I am now even more concerned than I was on Friday about the proposed height of the new (seven storey) multi purpose building above the rooftop level (light red roof) of the Old Gym building on the SCEGGS.

On Friday, based on looking at the second pdf plan attached showing the SECTIONS EE and FF of the proposed new building, I was misled into thinking that the proposed rooftop level of the new building is only about 1 to 1.5 metres higher than the existing Old Gym building.

Figure 17 – Proposed East West Section – Proposed Multi-Purpose Building

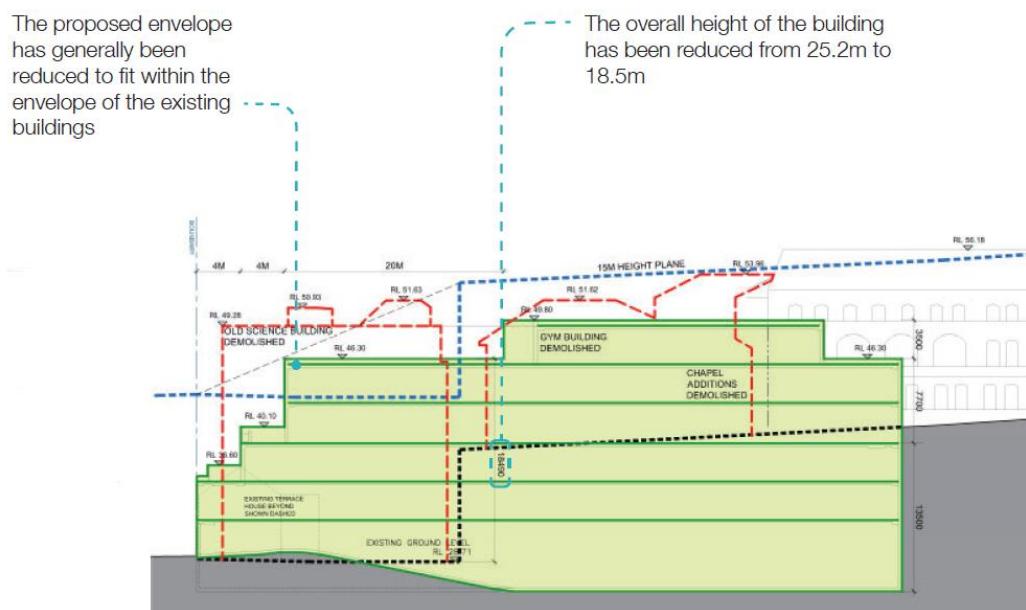
However the other attached pdf plan showing the existing levels of site buildings has the level of Old Gym building as RL 50.23 m and the new rooftop level of the proposed seven storey building is a full 2.77 metres higher at RL 53.00 m
